**KIRKLEES COUNCIL
TOWN AND COUNTRY PLANNING ACT 1990
HIGHWAYS DEVELOPMENT MANAGEMENT**

PLANNING REF 2017/62/91132/W0/WS
CATEGORY

PROPOSAL ERECTION OF TWO STOREY SIDE
EXTENSION TO FORM ENLARGED
CLASS A1 SHOP AT GROUND
FLOOR WITH RESIDENTIAL FLAT
ABOVE

LOCATION FIX IT SUPPLIES
12b HILLHOUSE LANE
FARTOWN
HUDDERSFIELD
HD1 6EF

Drawing number
2017 01 C.

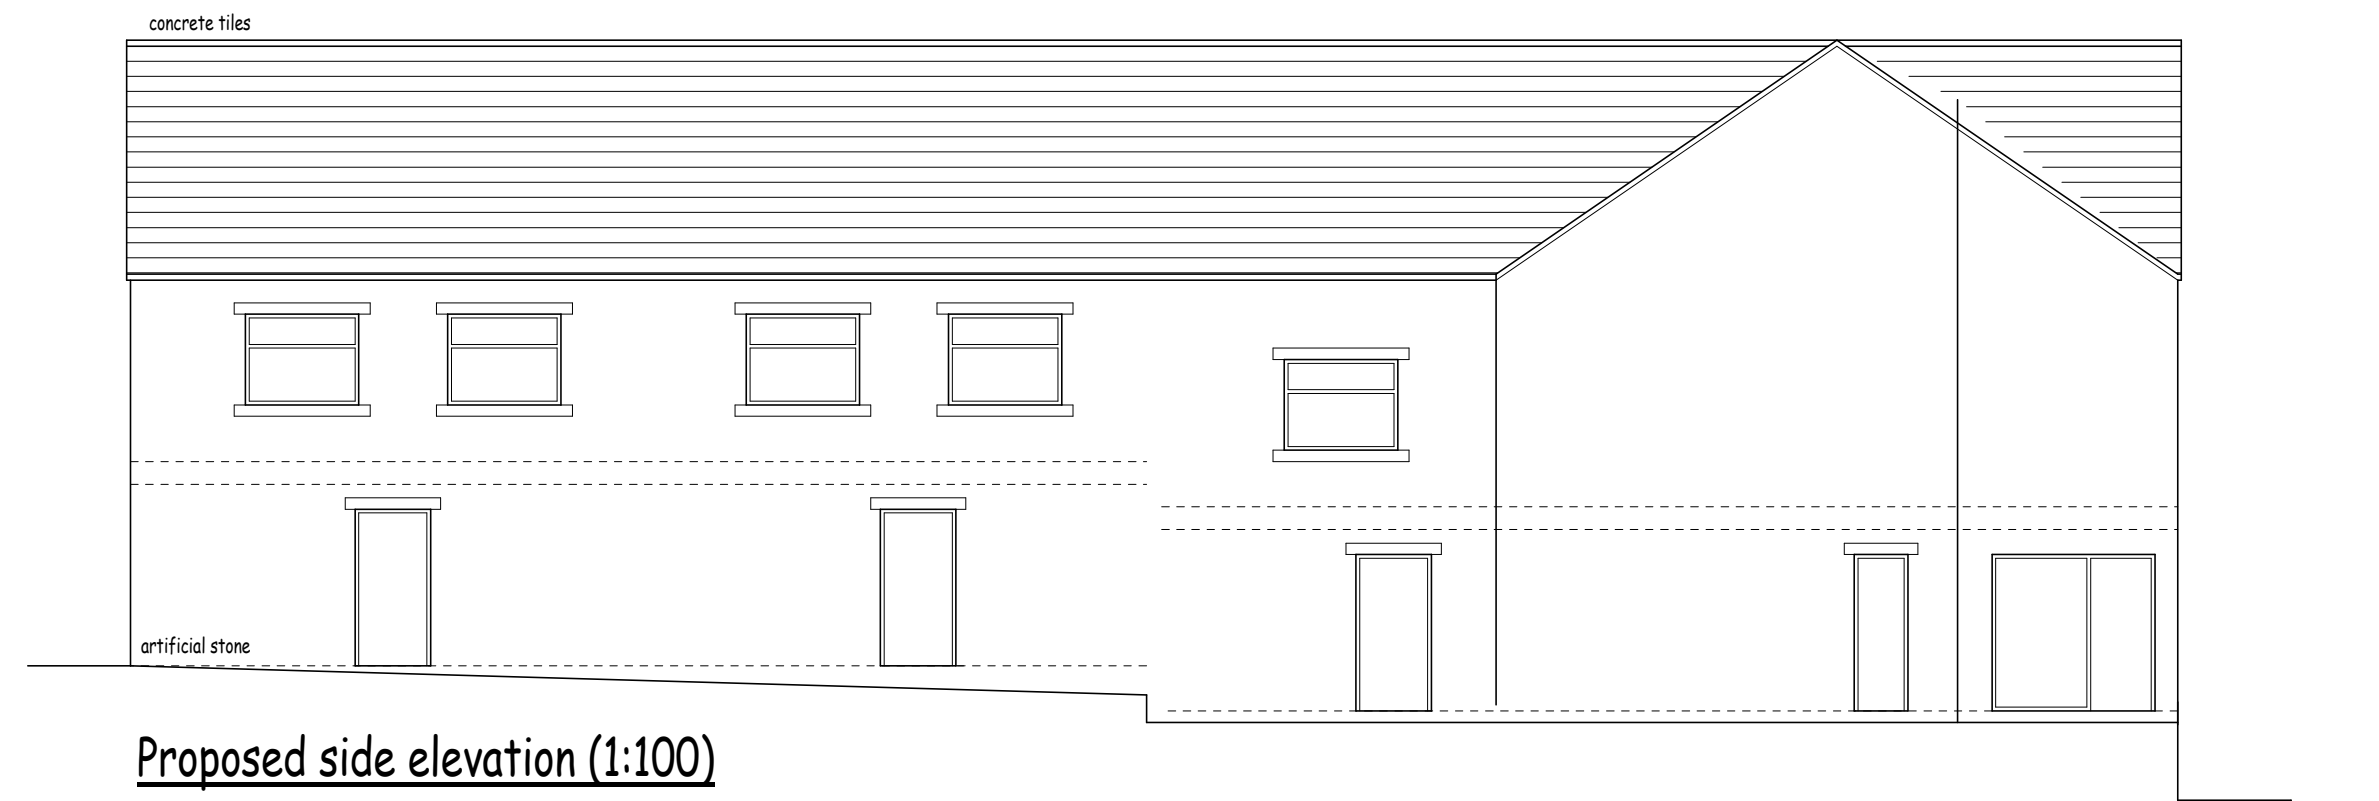
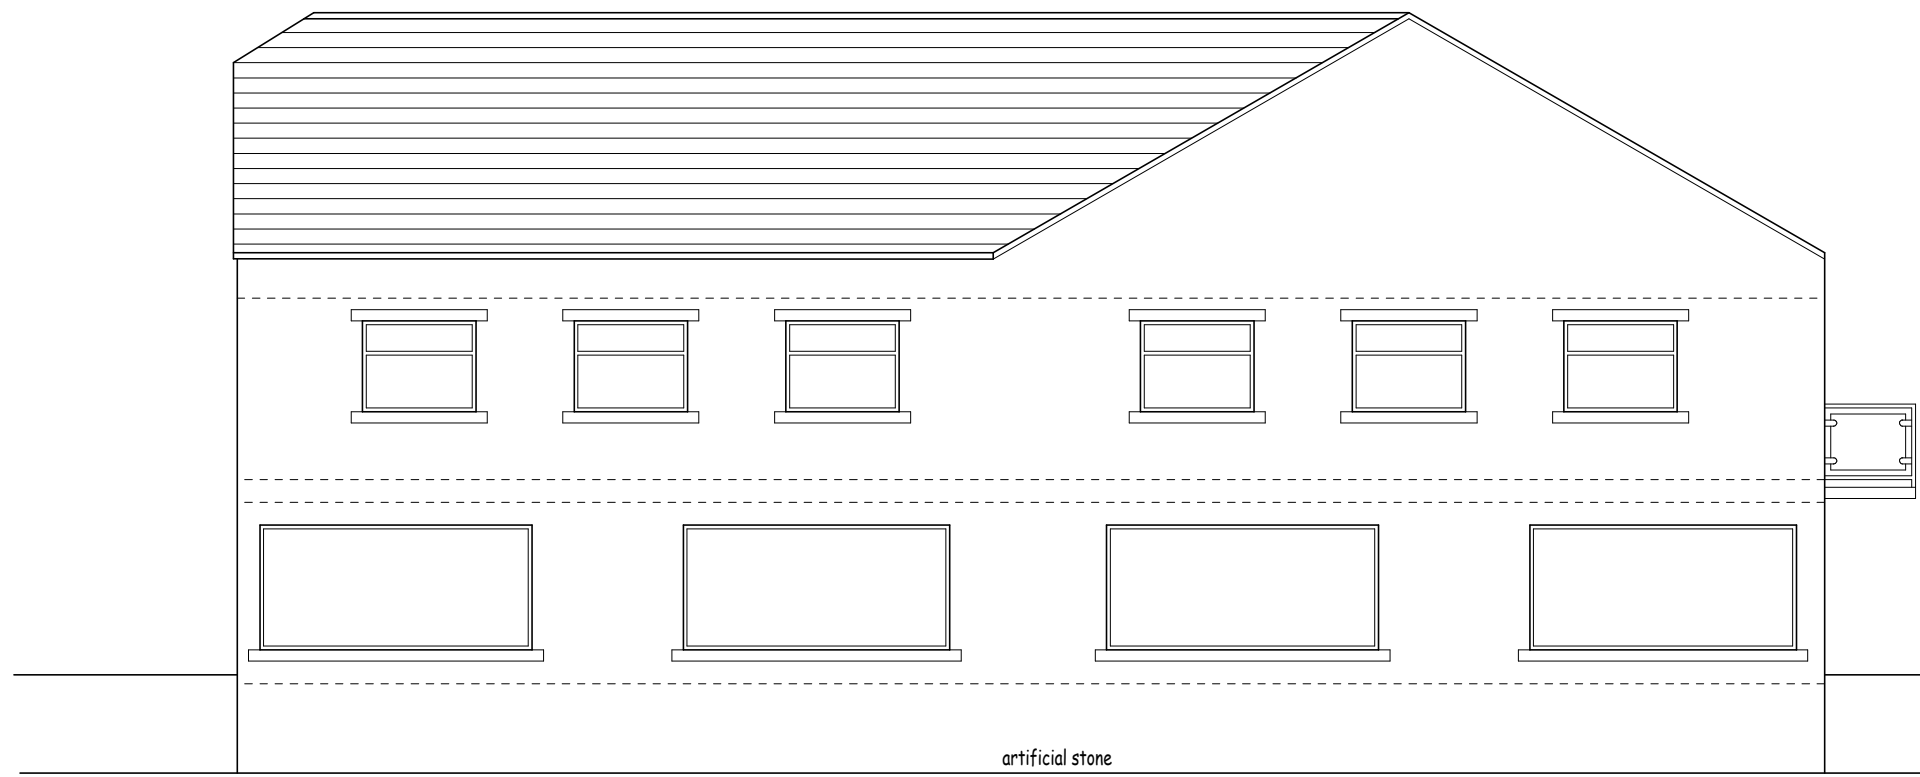
This application provides insufficient information for proper highways assessment, information regarding the use class of unit 10 on the first floor needs to be provided.

The extension to the shop provides an additional 126.5sq m of shop (A1 use class) floor space and therefore an additional 4 vehicular off-street parking spaces should be provided along with 1 space for the proposed flat and further parking for the additional 57.2sq m of floor space for unit 10 on the proposed first floor.
